WEST SUSSEX COUNTY COUNCIL CONSULTATION

TO:	Arun District Council FAO:Ms M Tomalova
FROM:	WSCC - Highways Authority
DATE:	6 July 2020
LOCATION:	Land adjacent to 84 North Bersted Street Bognor Regis PO22 9AQ
SUBJECT:	BE/48/20/PL Demolition of existing outbuildings & erection of 1 No dwelling. This application is a Departure from the Development Plan, affects the character & appearance of the North Bersted Conservation Area & may affect the setting of a listed building.
DATE OF SITE VISIT:	n/a
RECOMMENDATION:	Advice
S106 CONTRIBUTION TOTAL:	n/a

CLIENT	Mrs L Parker	DRAWING	004 Site Layout Plan (Tree Context)		
SITE	84 North Bersted Street, Bognor Regis	DATE	16 06 20	AUTHOR	AH
PROJECT	Proposed New Dwelling	SCALE	1: 200 @ A3	STATUS	PL

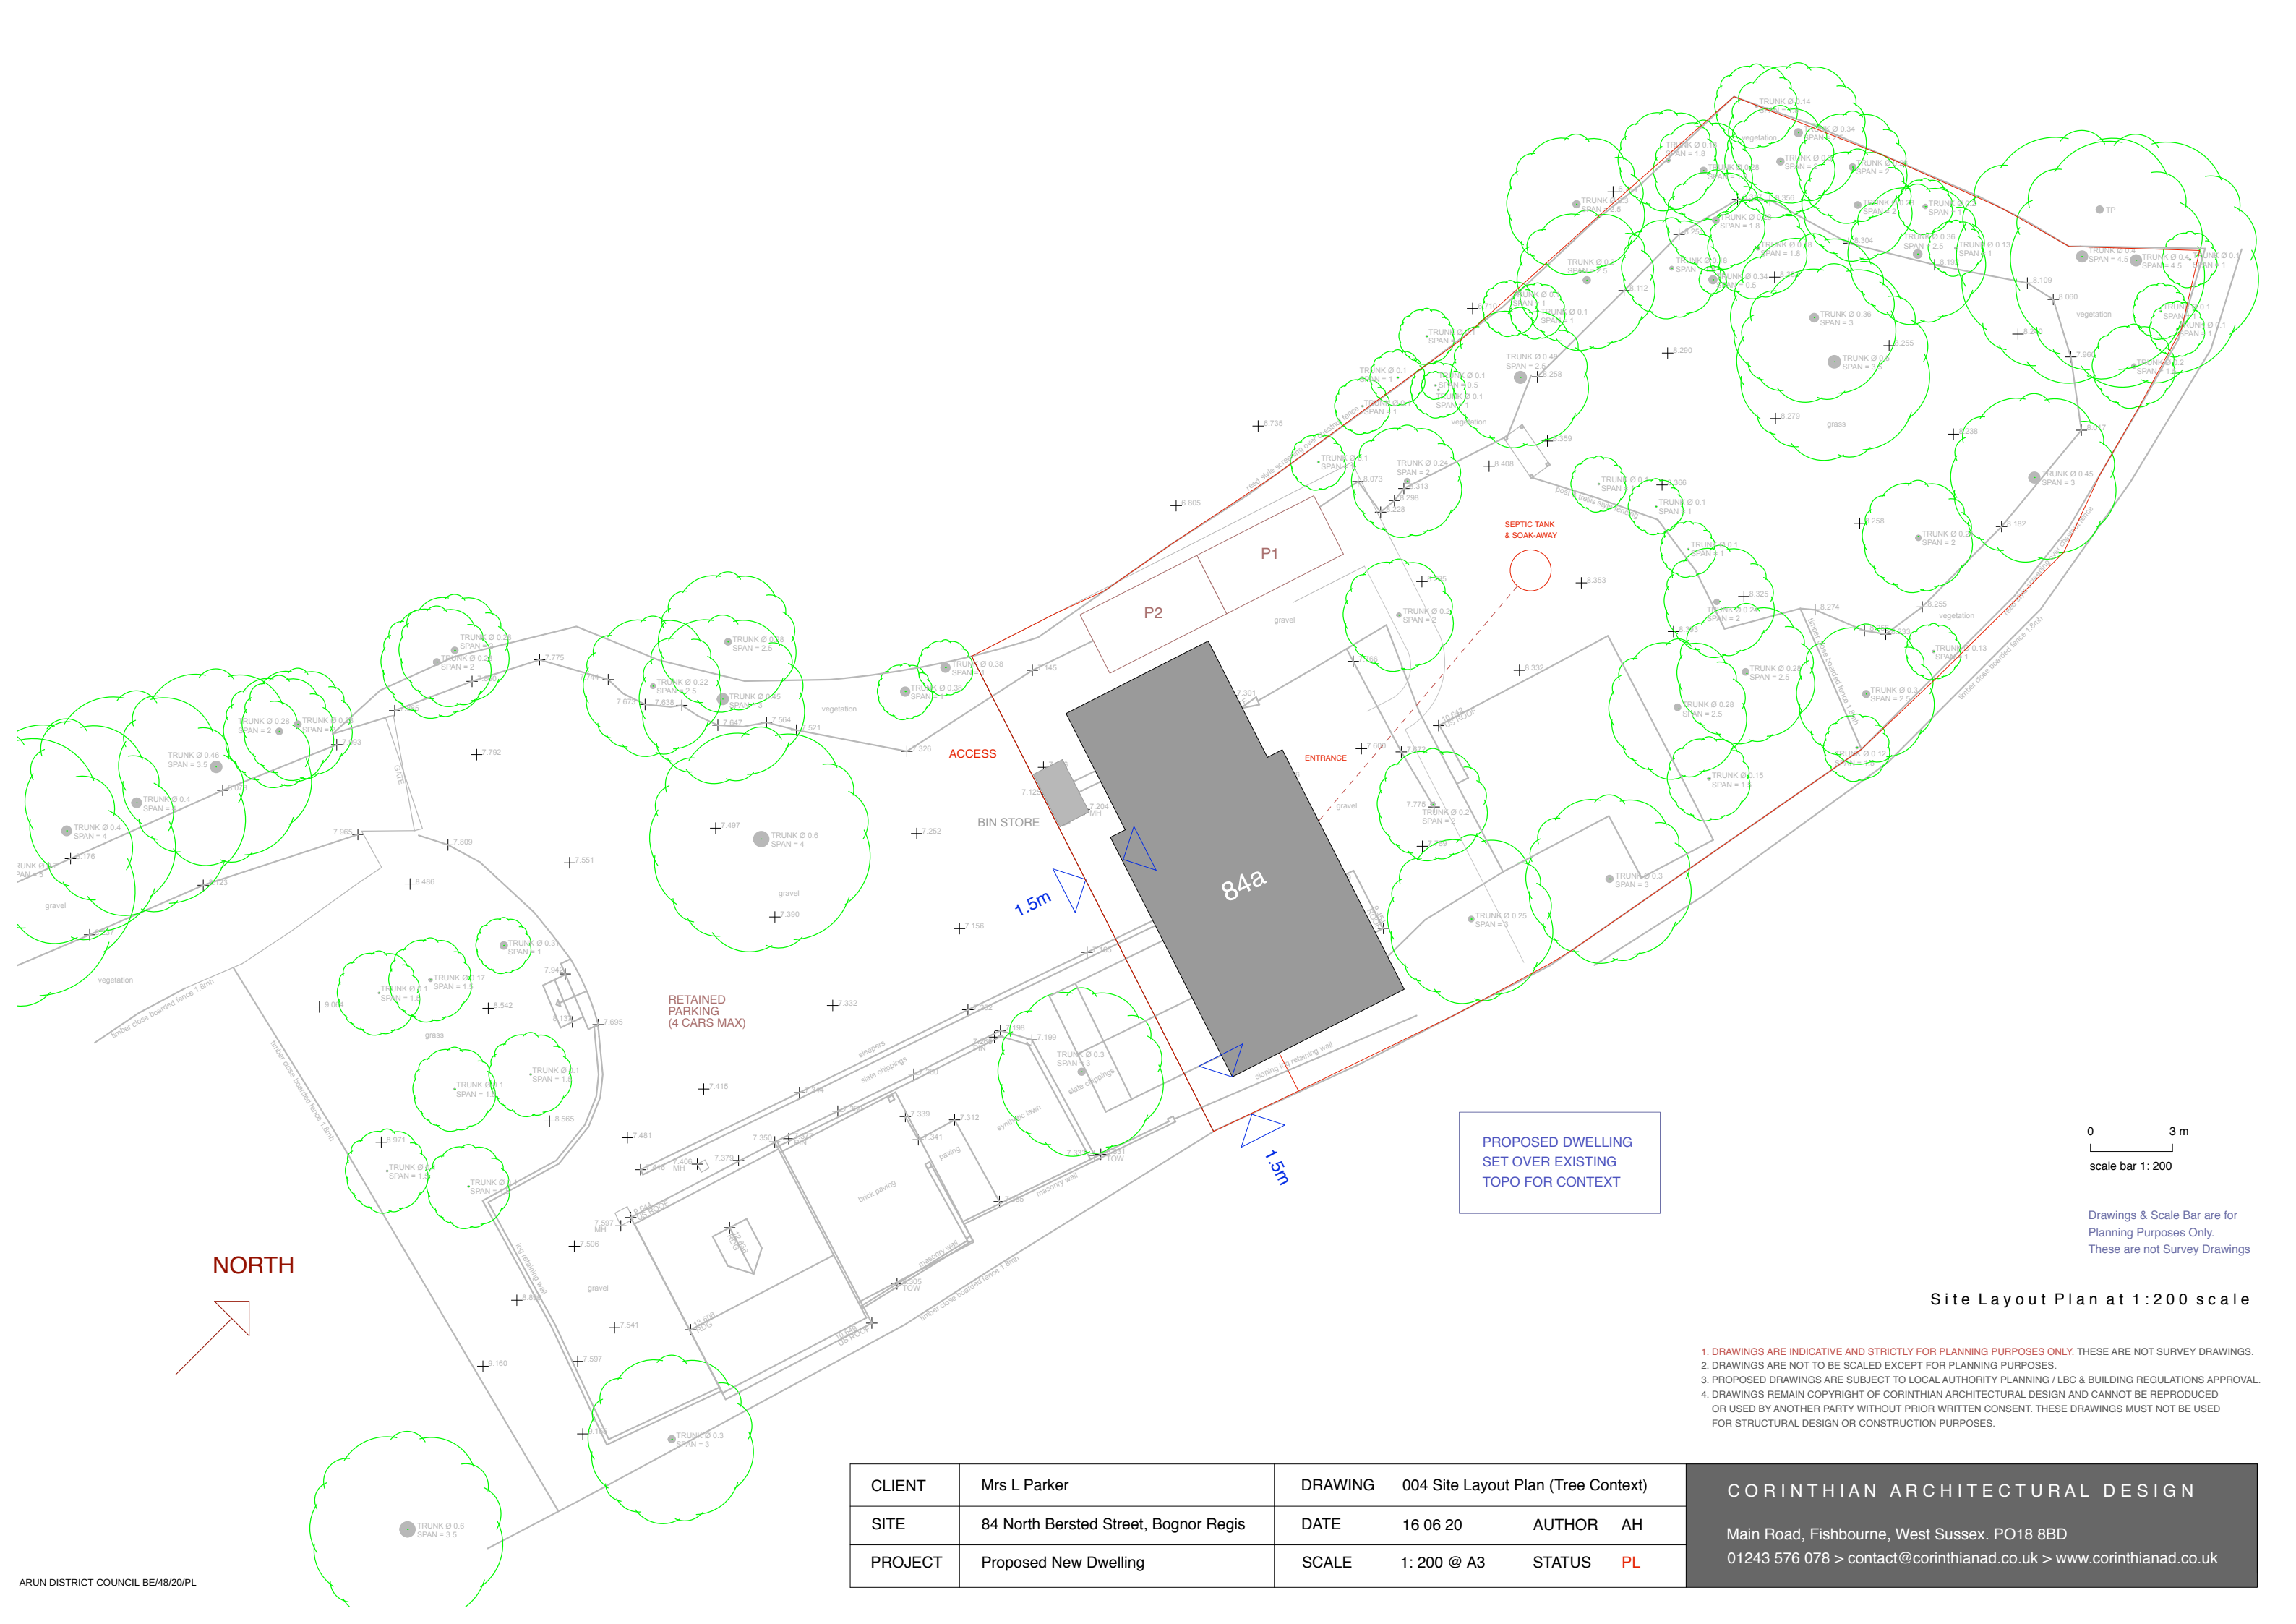
The proposed site layout plan demonstrates onsite parking provision of 2 spaces. The WSCC Car Parking Demand would expect at least 3 spaces to be provided for 4+ dwelling in this location. Each parking bay has the adequate dimensions of 2.4 x 4.8m as outlined in Manual for Streets (MfS) guidance. The site's curtilage appears of sufficient size to accommodate an additional parking space.

Vehicles are anticipated to have the ability to turn and egress onto the public highway in forward gear.

No part of the development shall be first occupied until the car parking has been constructed in accordance with the approved site layout plan 004. These spaces shall thereafter be retained at all times for their designated purpose.
